KITTITAS COUNTY COMMUNITY DEVELOPMENT SERVICES

April 26, 2018

RE: VA-18-00002 Scholl

Mike Flory,
Building Official

Perry-BACH Additions		
SCALE: _____	APPROVED BY: _____	DRAWN BY OTH BACH
DATE: 4/1/03		REVISED
Site Plan

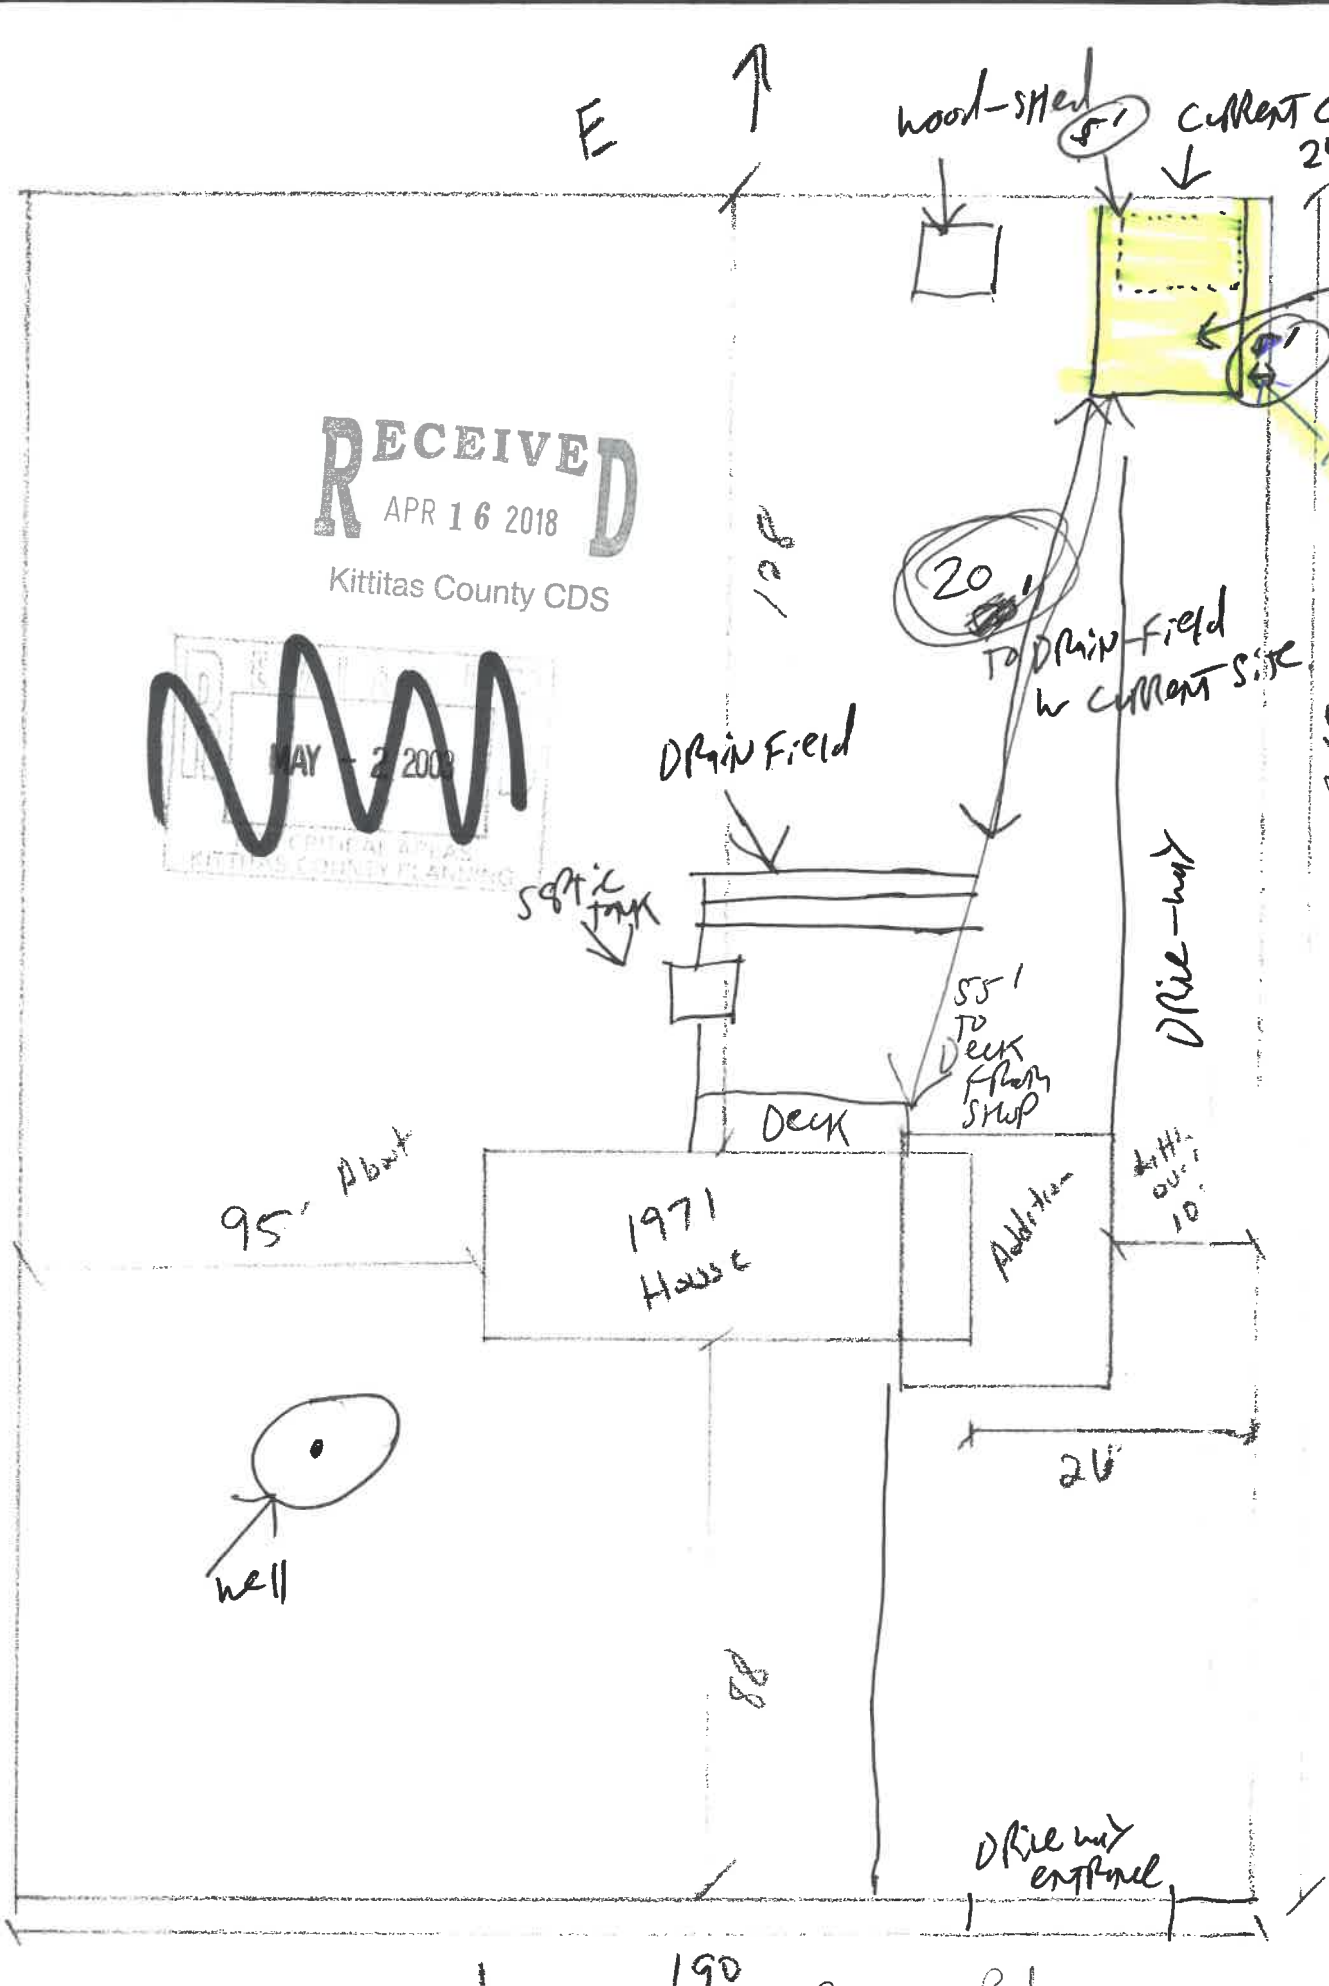
1. The five foot rear setback requested does not need to be fire protected. Any closure encroachment to a property line would require firewall construction. A building eave may encroach into the five foot setback as long as it is fire protected or fire-blocked per the current edition of the IRC or IBC at the time of permit submittal.
2. All construction of buildings and garages shall conform to the International Building Codes and the International Residential Codes adopted at the time of building permit submittal. This includes firewalls and fire separations.
